Qantas Flight Training Centre (SSD 10154) - Response to Submissions

Thank you for your correspondence dated 26 August 2019, requesting Transport for NSW (TfNSW) to review and comment on the above.

B99 VEHICLE SWEPT PATHS

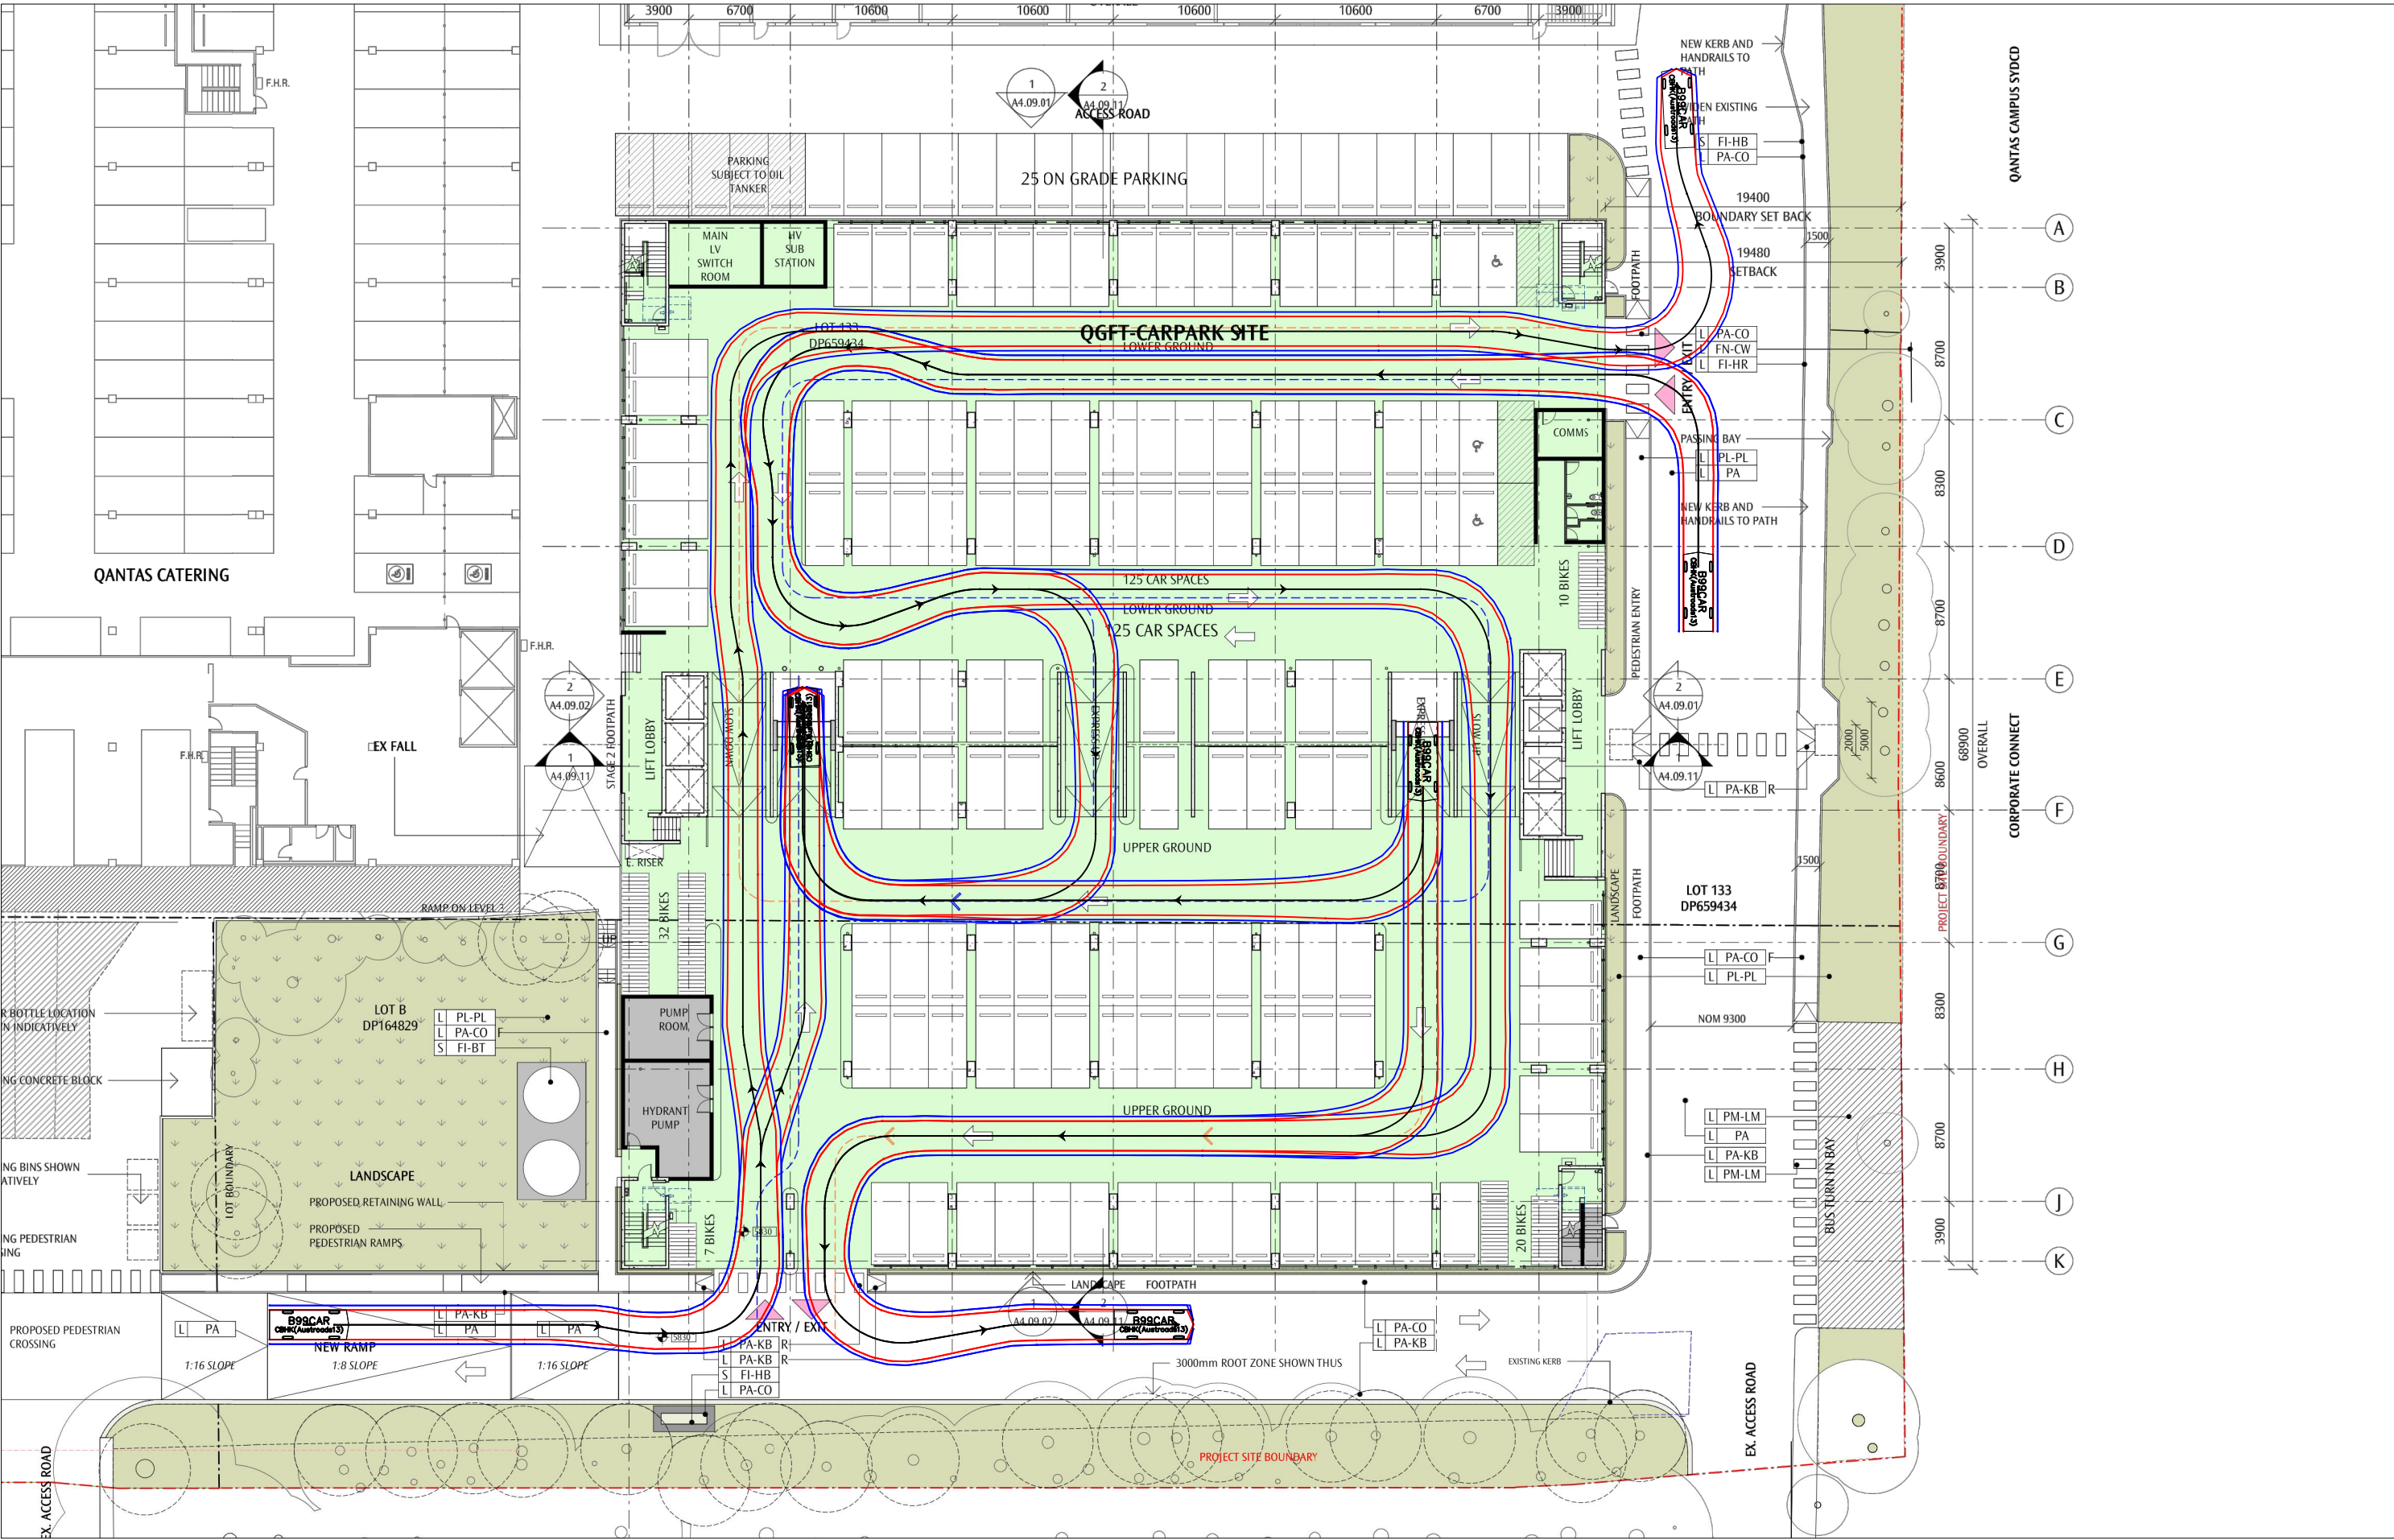
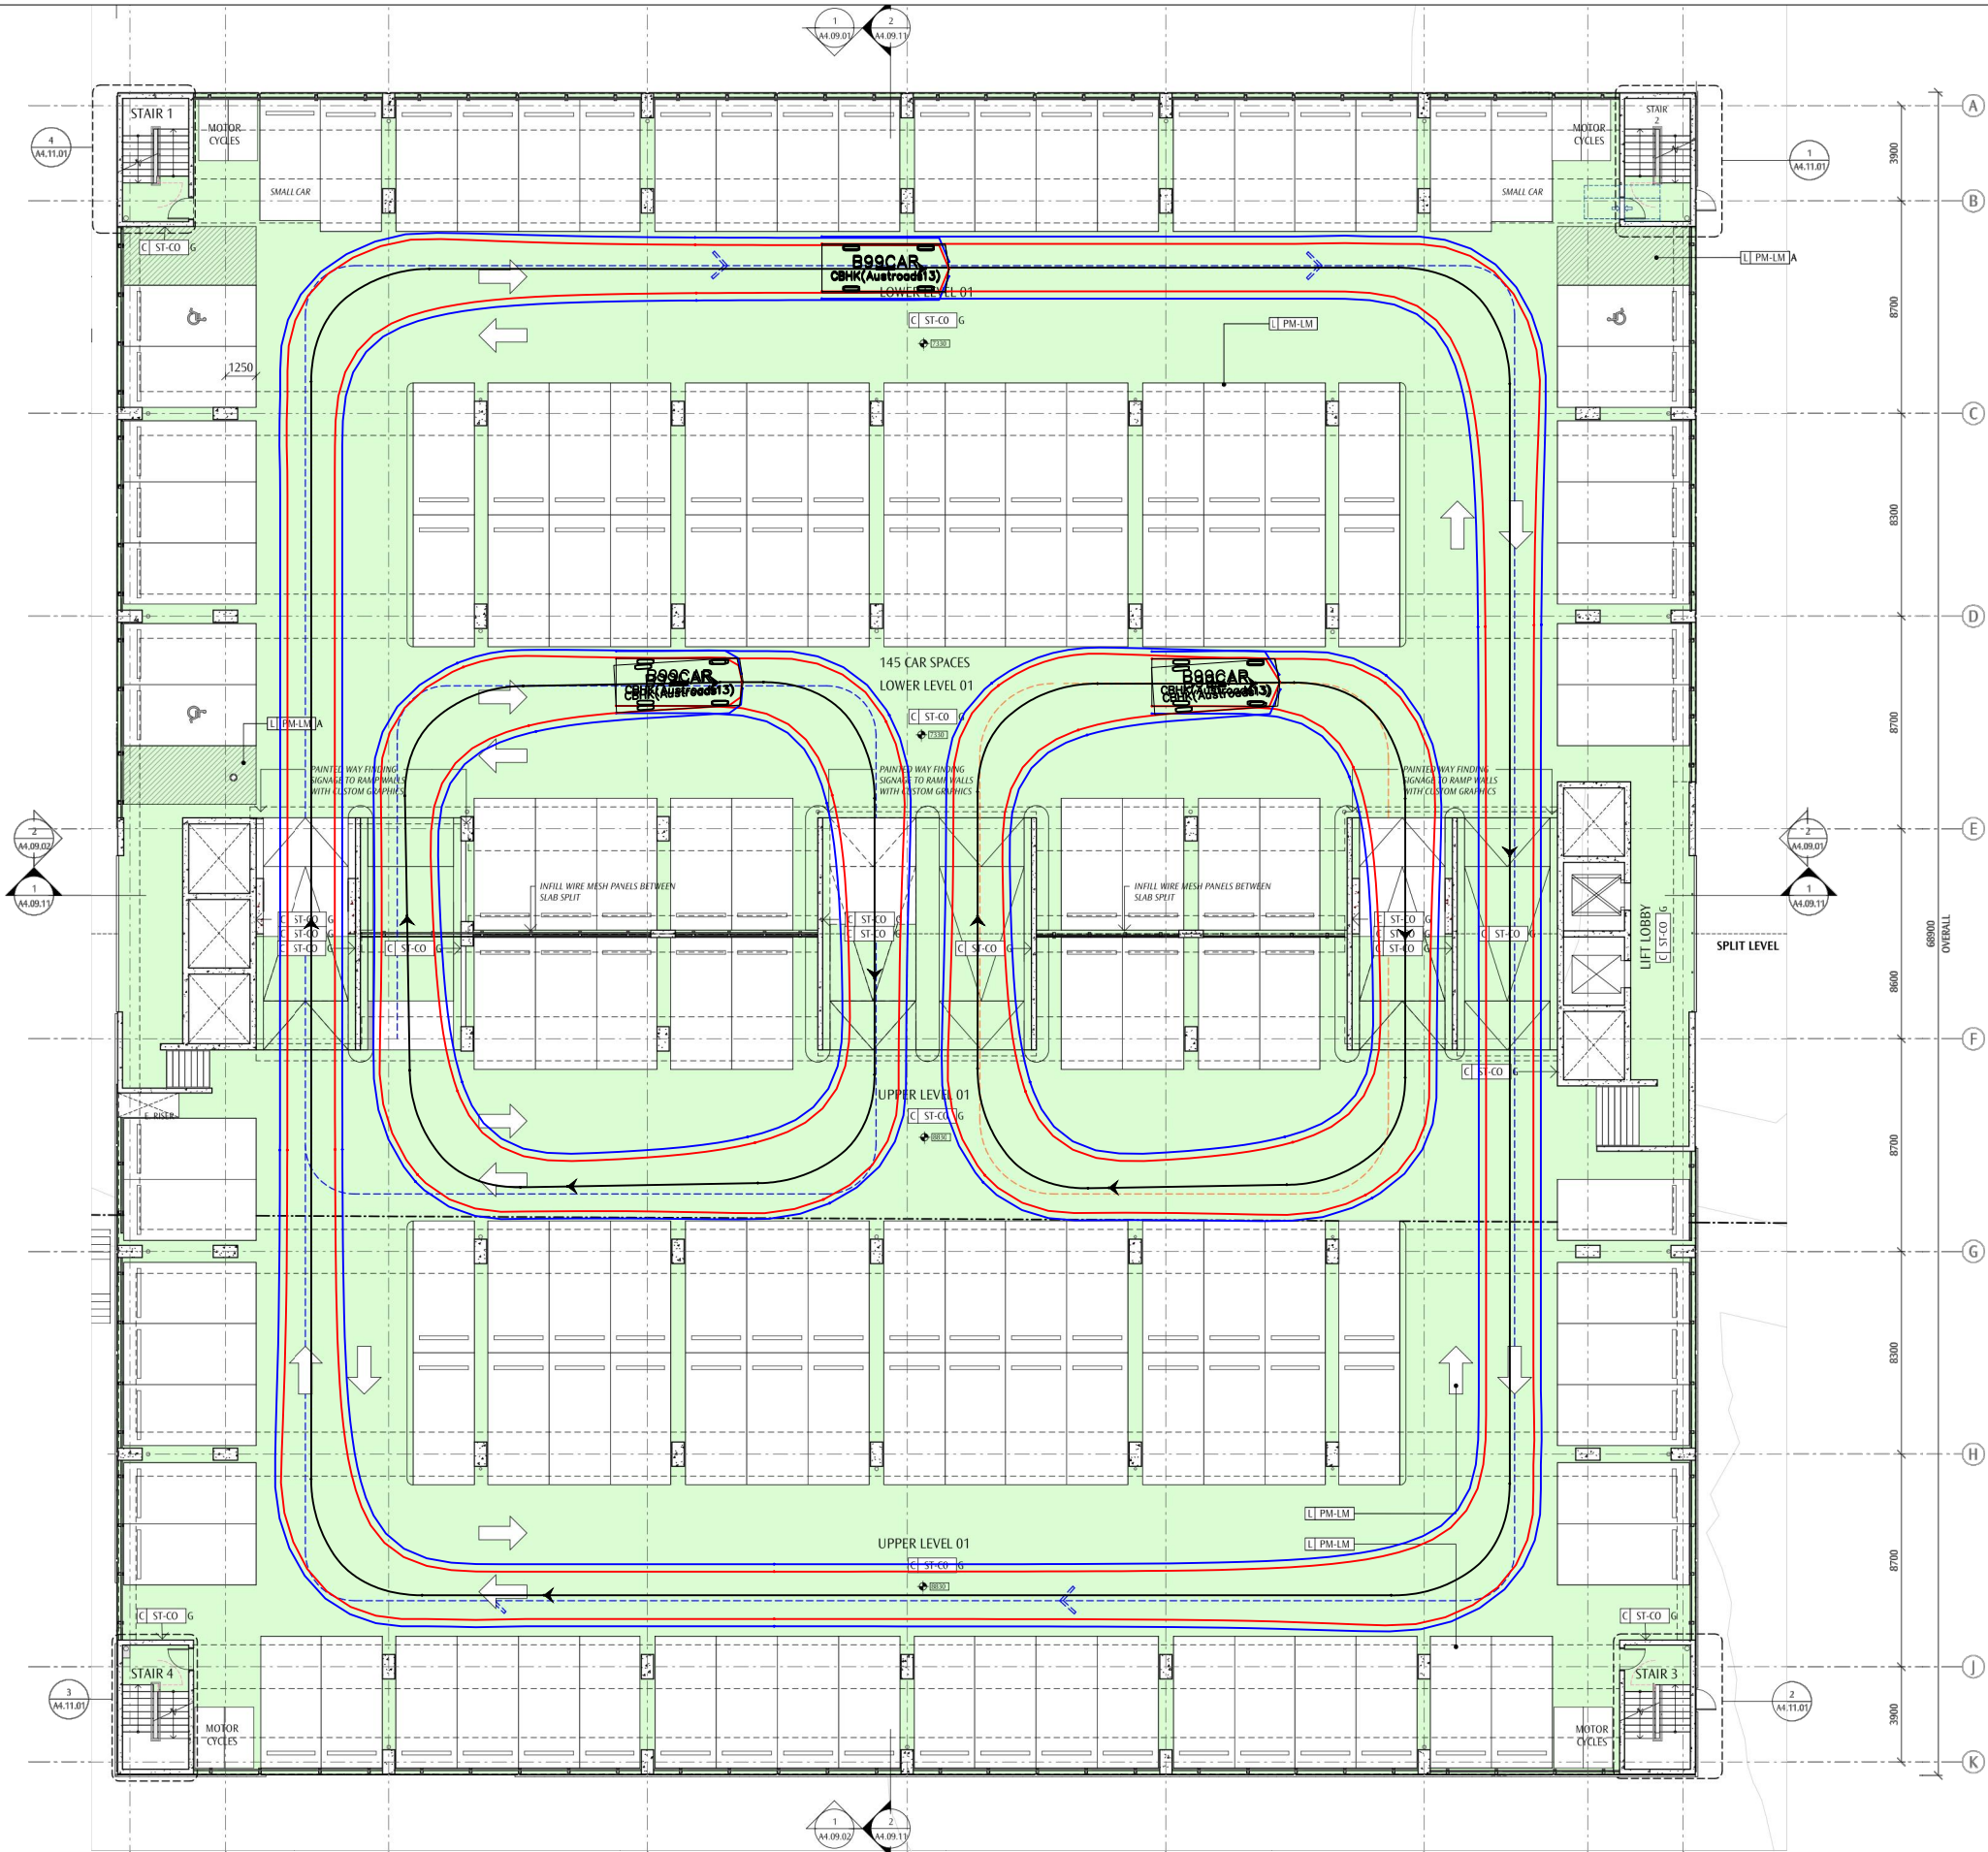
It is noted that the report mentions use of articulated vehicles. However, the swept path analysis includes a movement of a B-Double vehicle. If the proponent intends to run B-Doubles, a separate permit from the National Heavy Vehicle Regulator (NHVR) will be required. Any vehicle should arrive and depart the site in a forward motion.

It is requested that the applicant be conditioned to require all vehicles entering and leaving the site to do so in a forward motion. Note that if B-Doubles are intended to be used, a permit will need to be obtained from the National Heavy Vehicle Regulator (NHVR).

All vehicles entering and leaving the site shall do so in a forward motion. Note that if B-Doubles are intended to be used, a permit will need to be obtained from the National Heavy Vehicle Regulator (NHVR).
